MP08_0241 - Section 75W Modification Application 100 Mount Street North Sydney – Response to Council, Railcorp and the Department of Transport Submissions

We provide the following response to the matters raised by North Sydney Council, Railcorp and the Department of Transport in relation to the above 75W application.

scale	1:50 @ A3, 1:200 @ A1	drawing no.	DA130
drawn	-	checked	MC
checked	MC	project no.	110059
project no.	110059		A

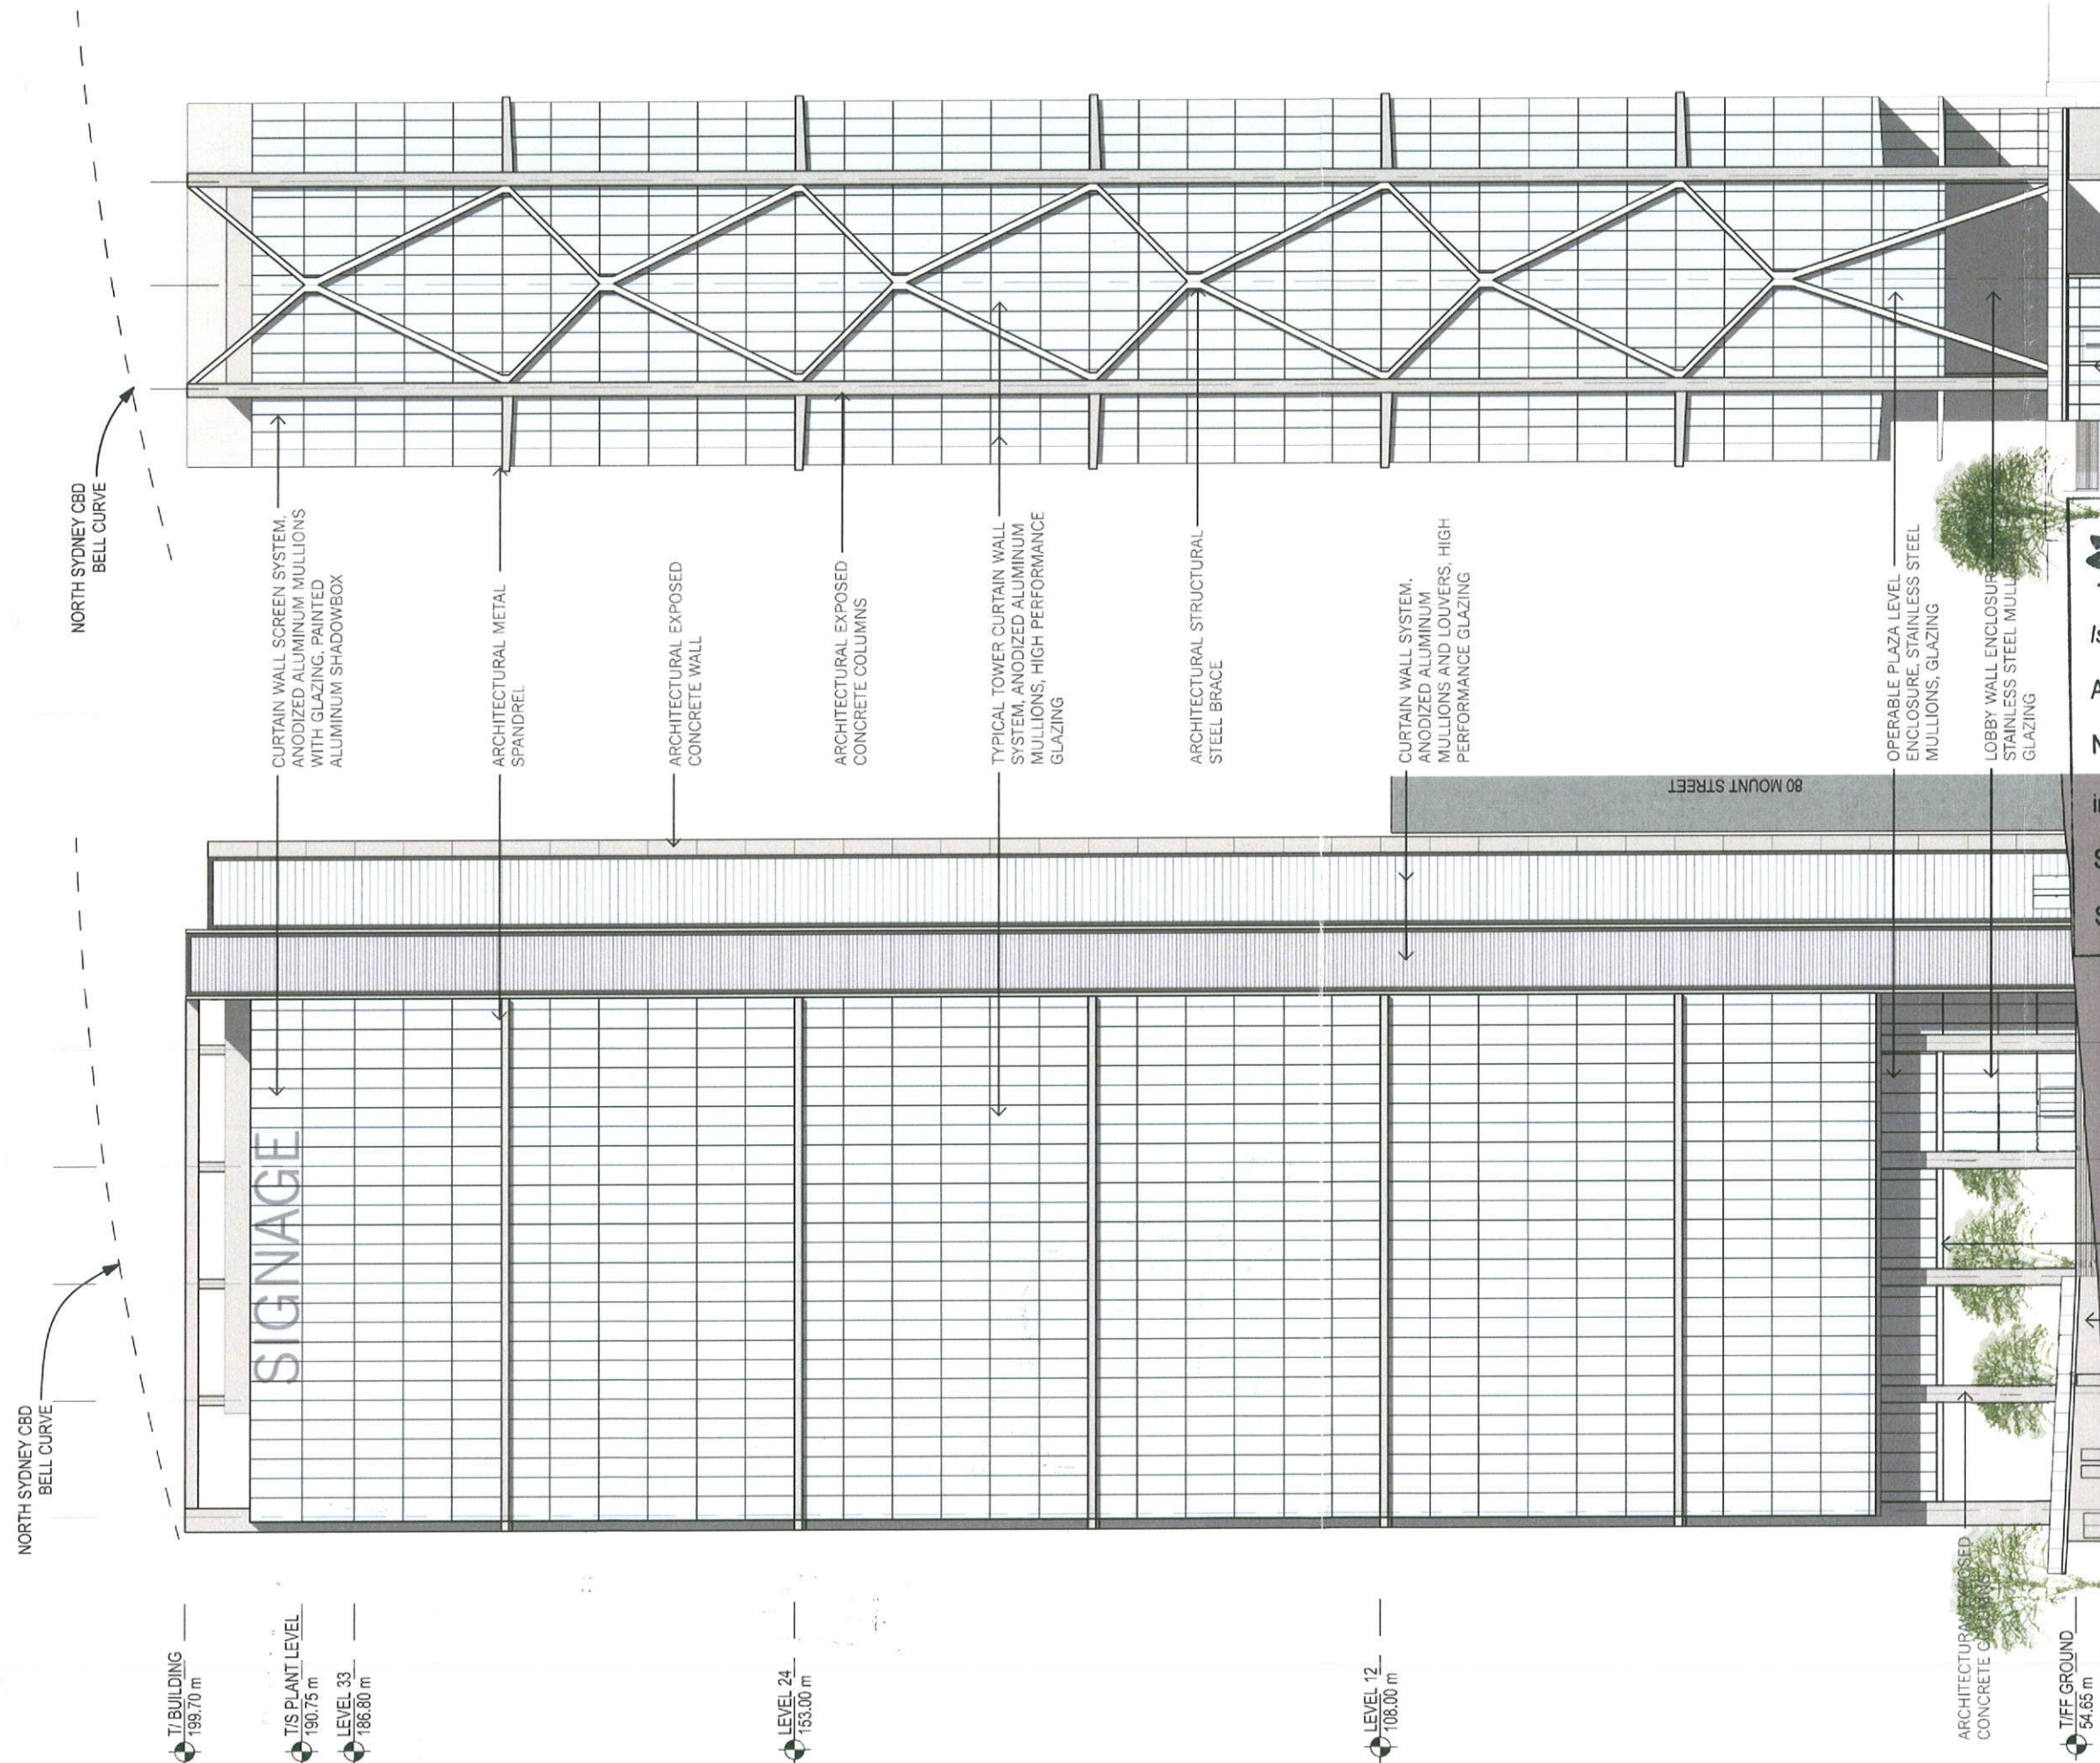
MOUNT STREET ELEVATION

It is proposed to retain the 4.2m setback to Walker Street shown in the Mount Street Elevation. This setback is in accordance with the existing condition of consent that specifies:

To the extent that the structural frame is the issue, this structure represents a very minor portion of the façade and does not significantly contribute to the bulk of the building. When viewed from an oblique angle, the structural protrusion does not detract from the principal setback and the alignment of this glass façade with others glass facades along Walker Street. The frame and exposed columns

represent an elegant architectural expression of the buildings structure when viewed from both near and afar. It replaces louvres and sunshades projecting into the 4.2m setback that were a feature of the previous scheme
